April 26, 2013

**Re: Comfort Dental Coronado, 5820 Menual Blvd, Traffic Circulation Layout  
Architect's Stamp dated 4-10-13 (H18-D068)**

Based upon the information provided in your submittal received 4-11-13, the above referenced plan cannot be approved for Building Permit until the following comments are addressed:

**A6 Entry Ramp / Stair Enlarged Plan**  
Scale: 3/8" = 1'-0"

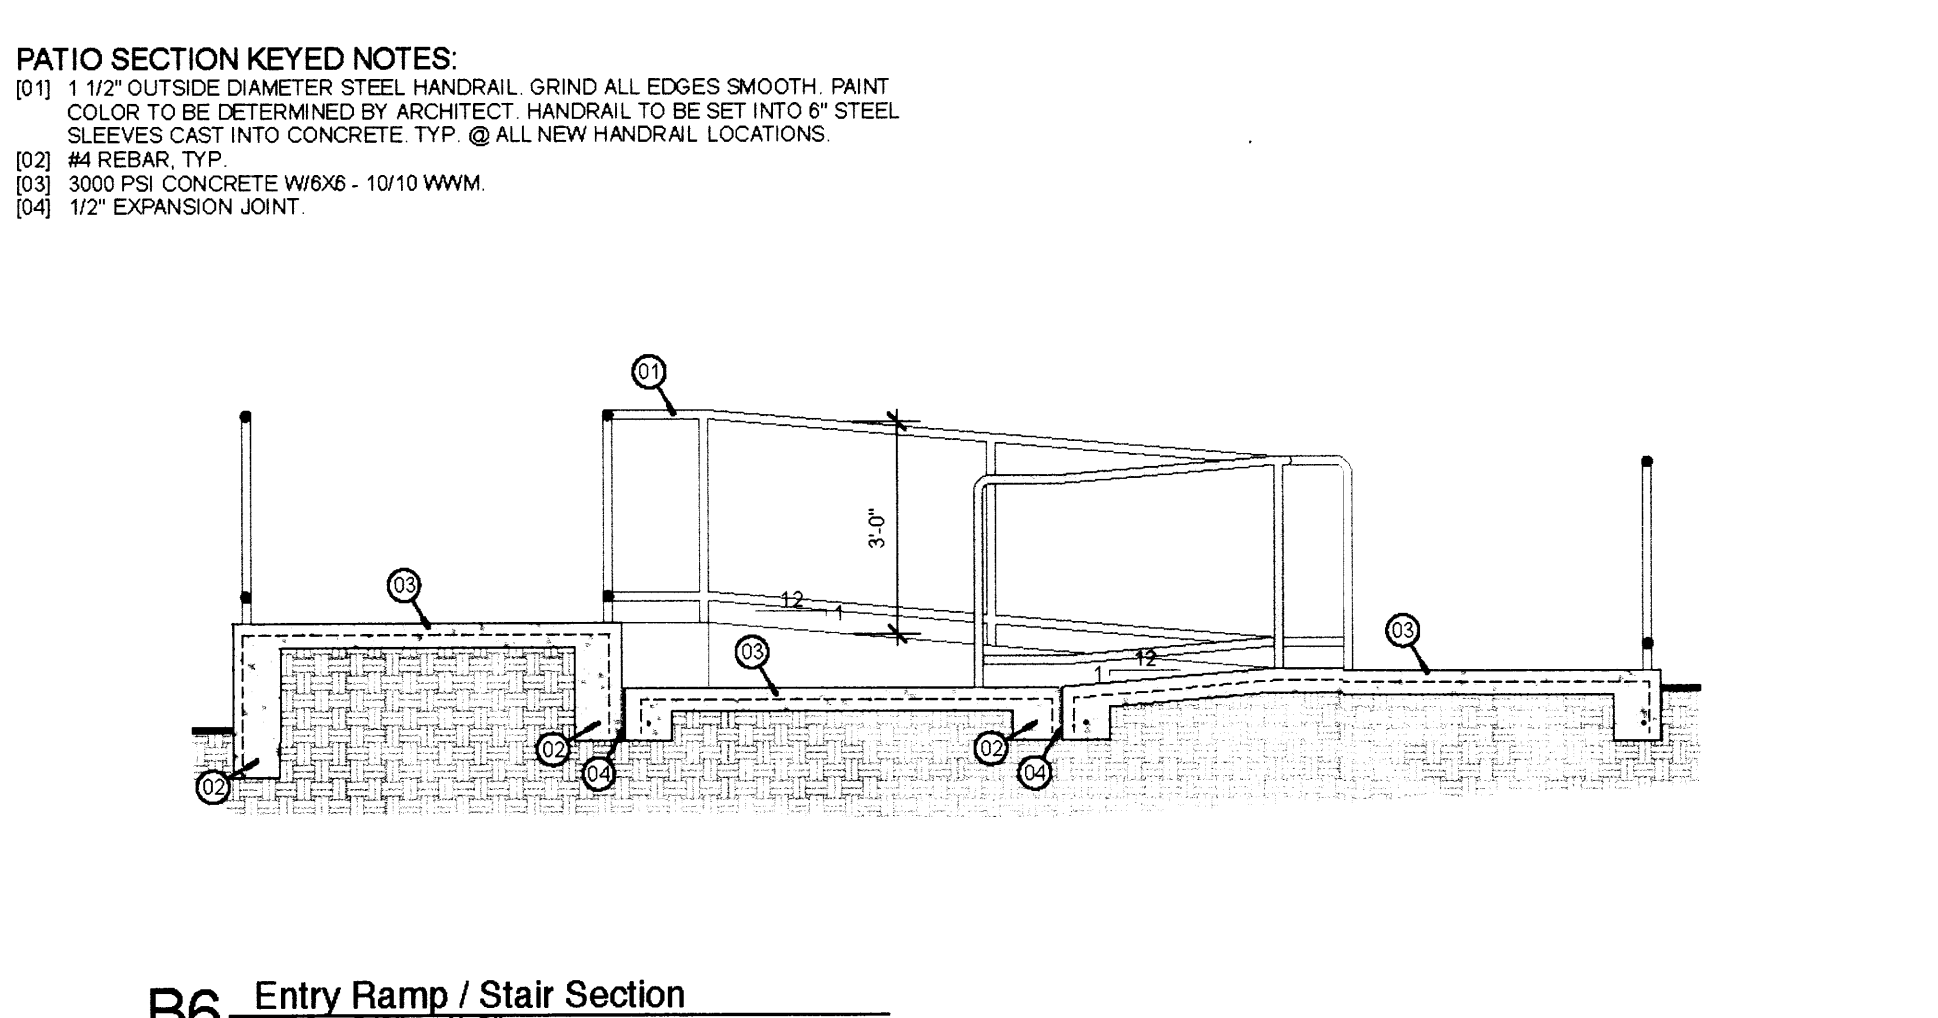
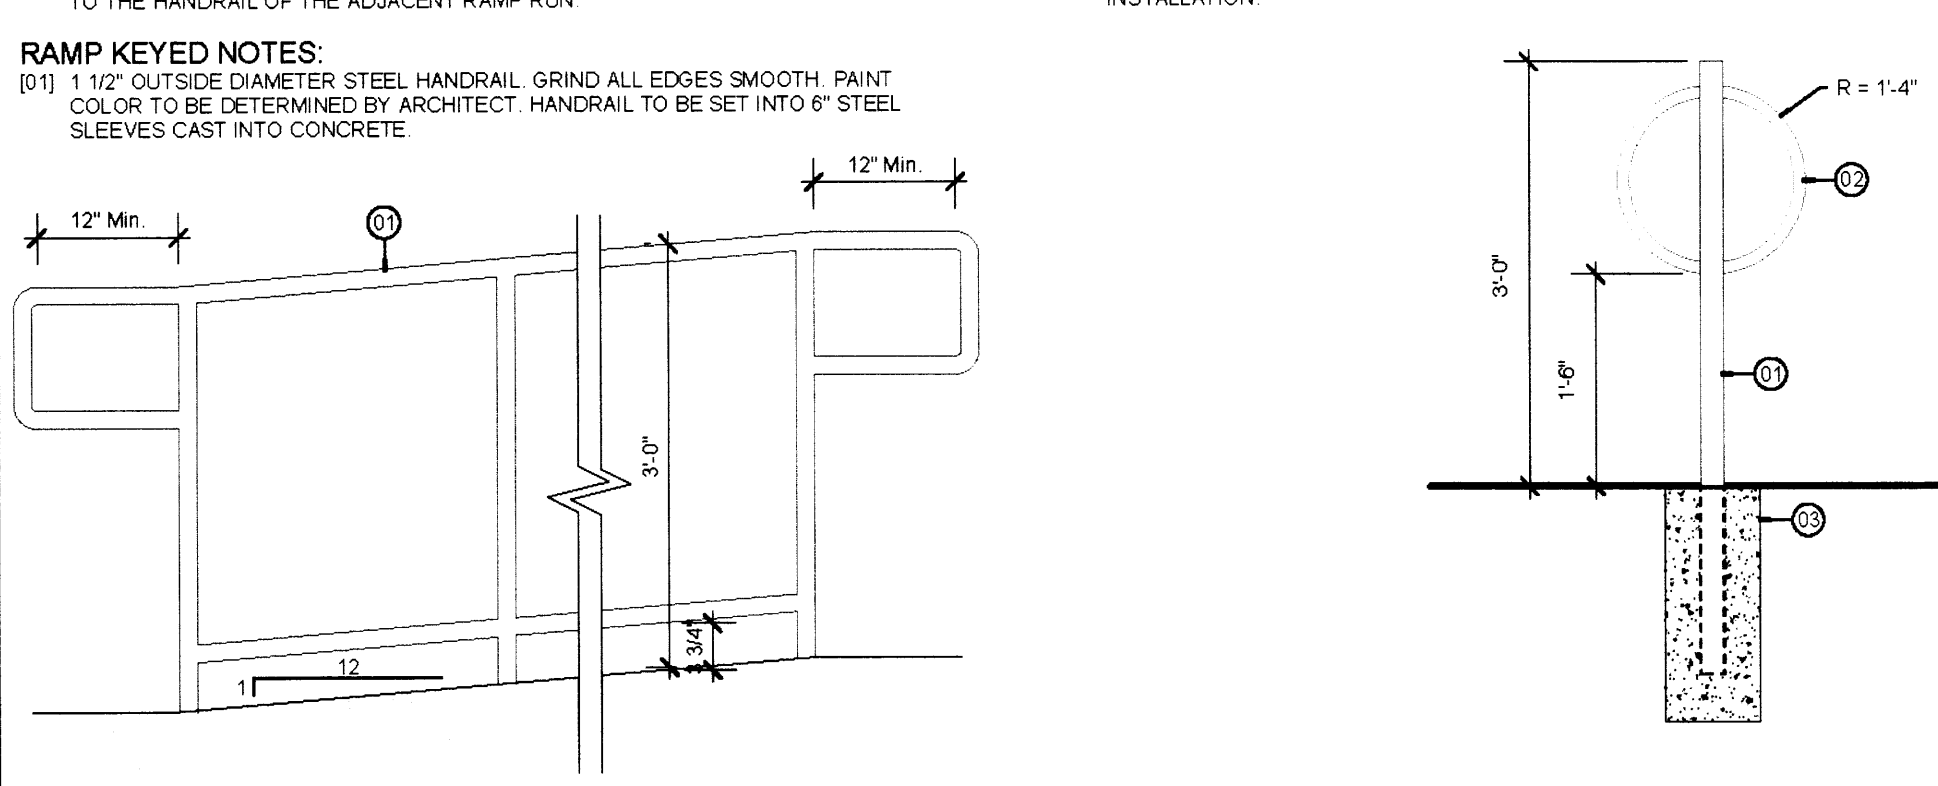
1. Please refer to all applicable city standards.
2. Please ensure all ramps are ADA compliant.
3. Please define all line-types and hatchings and note existing or proposed for clarification.

D4 Site Plan  
Scale: 1" = 10 ft

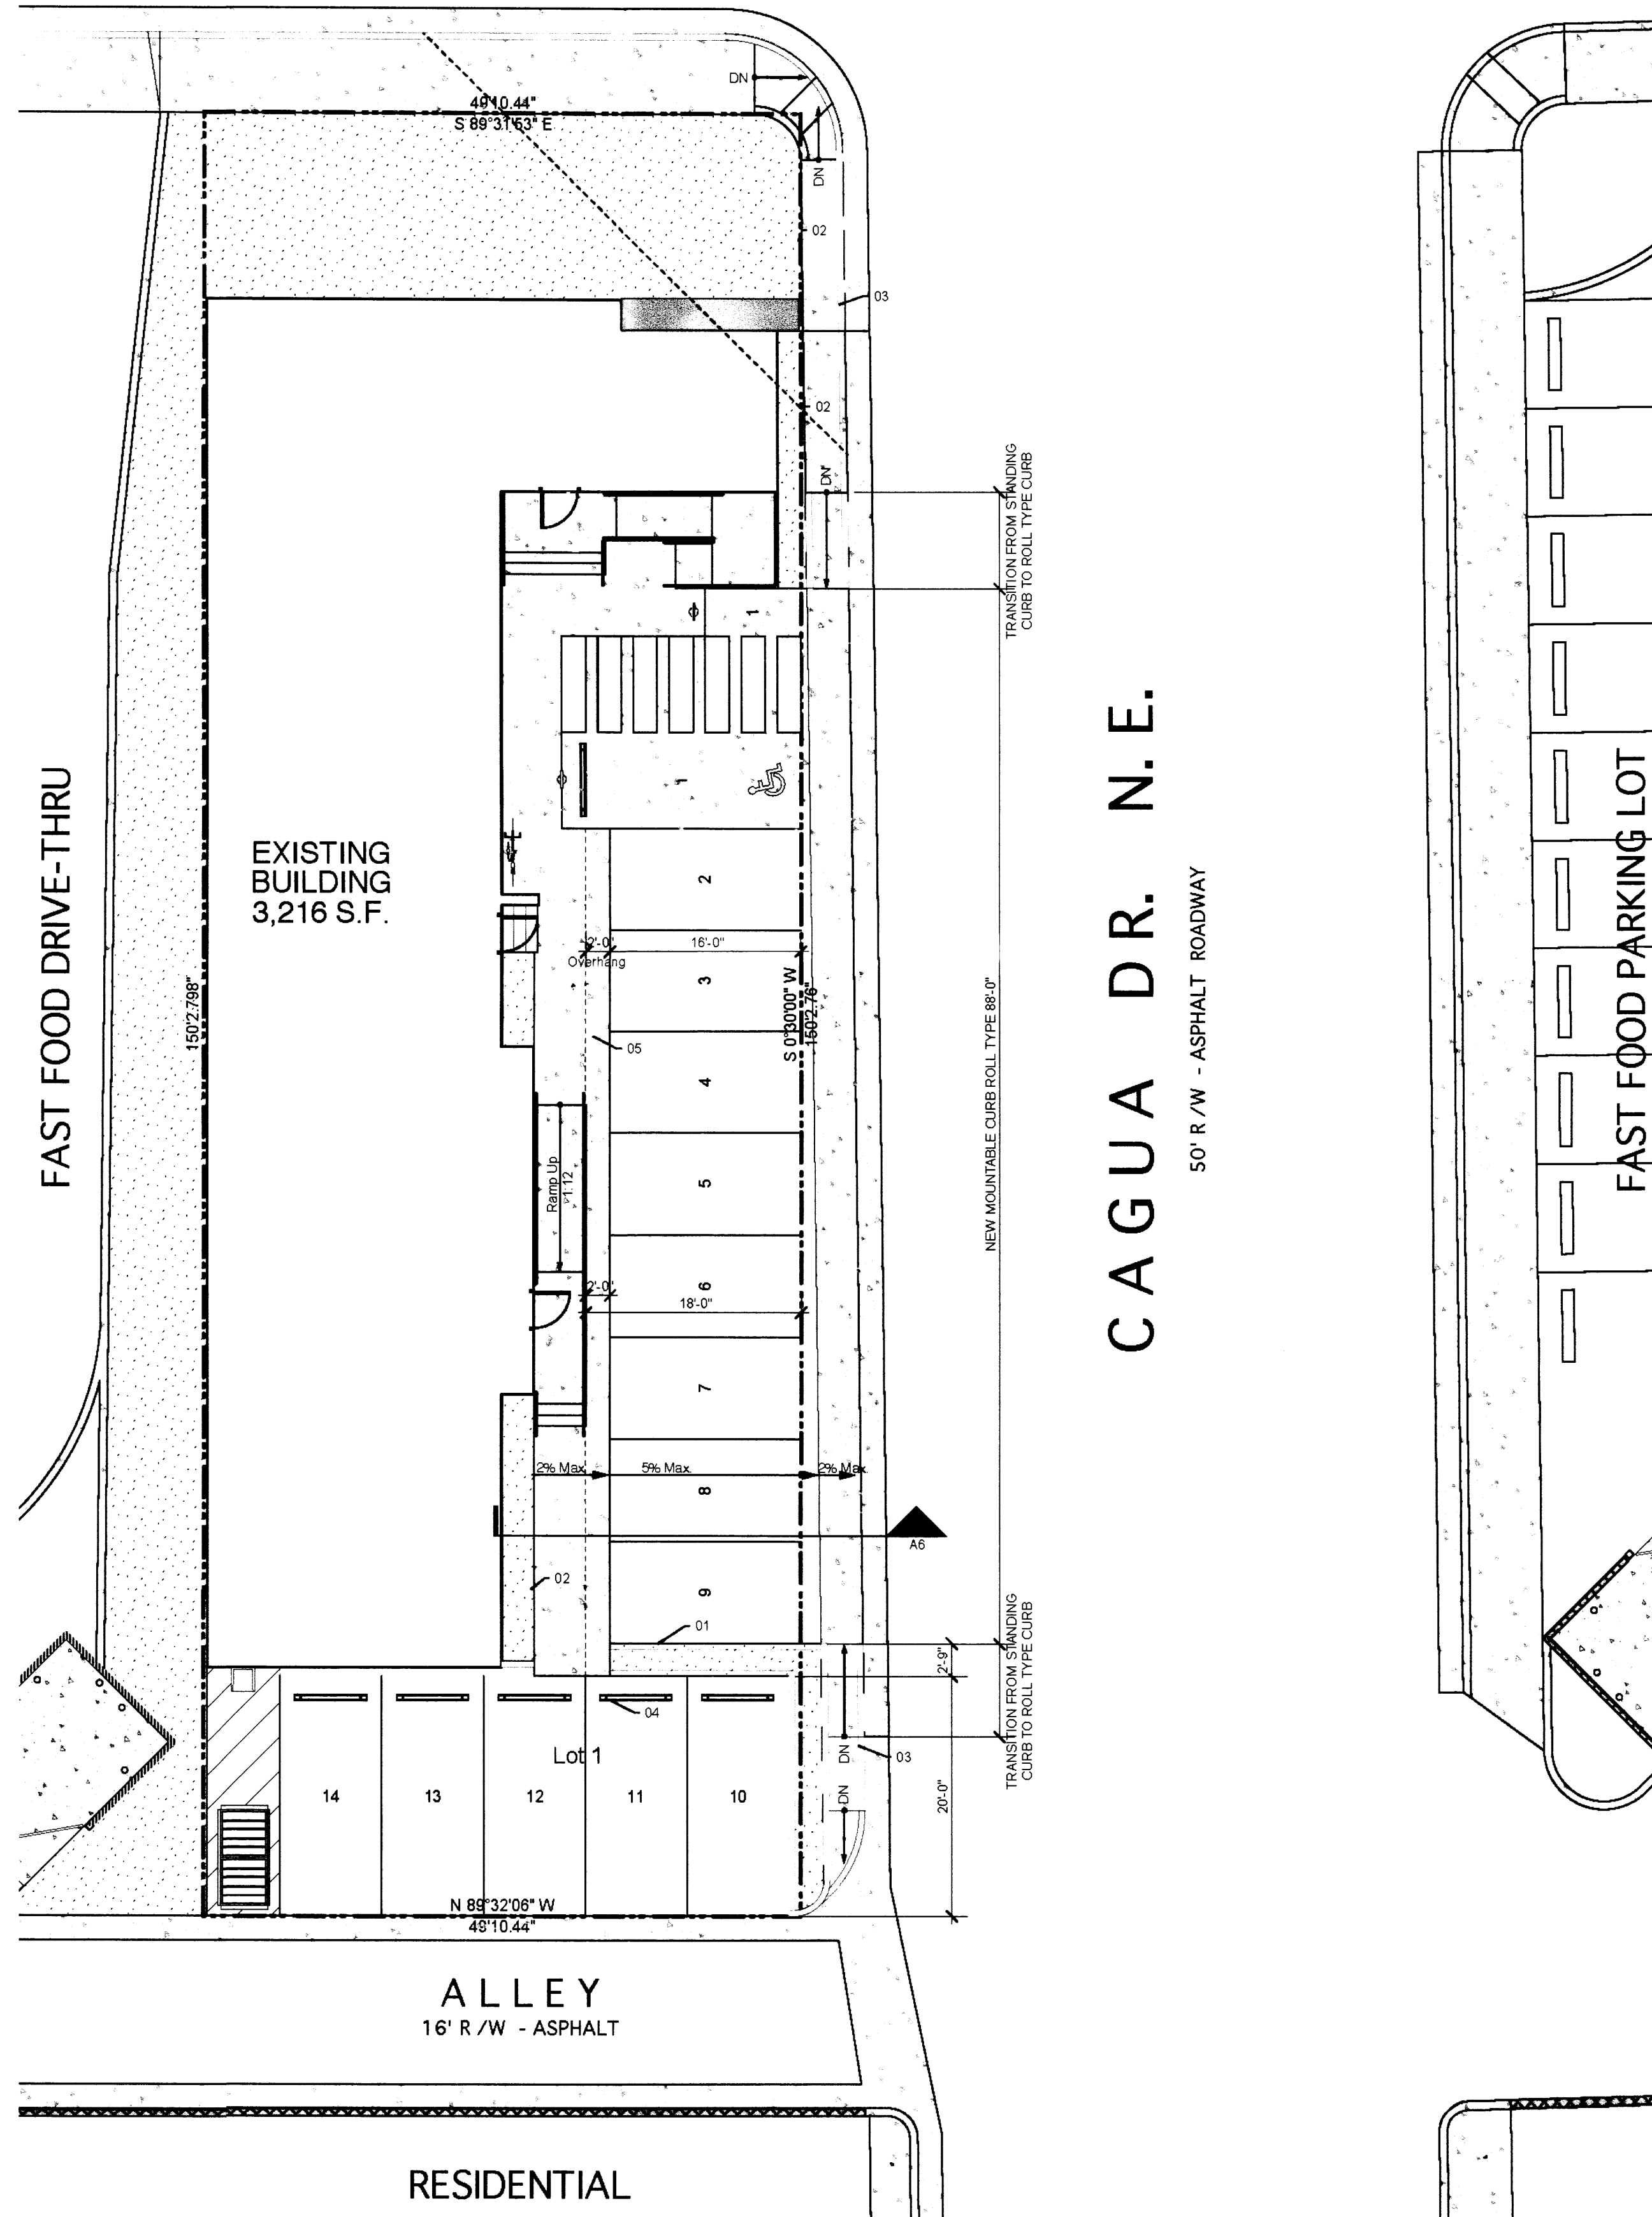
4. Define width of the existing sidewalk.
5. List the width of the existing drivepad.
6. Please provide details of the proposed 88 foot curb cut with sidewalk incorporated to comply with ADA regulations and DPM standards.

7. Show a detail of the wheelchair ramps located at the proposed driveway, or refer to the appropriate city standard.
8. Per DPM, vehicles are not allowed to back onto city streets. The City Transportation Engineer must provide a variance for this request.

9. Per Chapter 23, Section 6, Part B.5 of the City of Albuquerque *Development Process Manual*, any drive on a local roadway that is intersecting with a minor arterial must be located a minimum of 50 feet from the intersection. Please demonstrate compliance.

14. The proposed landscaped area at the corner of Menaul Blvd and Cagua Dr. must not interfere with the sight distance of the intersection. Please provide a sight distance exhibit (see the *Development Process Manual*, Chapter 23, Part B, Section 5.a).

15. Wheel stops set back 2 ft are required where parking space abut building.  
16. The landscaping (keyed note 04) adjacent to alley parking and public sidewalk requires header curb to contain.  
17. The landing area adjacent to the proposed HC ramp appears to share the same space as the parked bicycles. Please demonstrate the pedestrian path will remain unobstructed.  
18. Please provide details of the ramp and handrails for ADA compliance.  
19. Is there a pedestrian path provided from the vehicle parking stalls off of the alley?
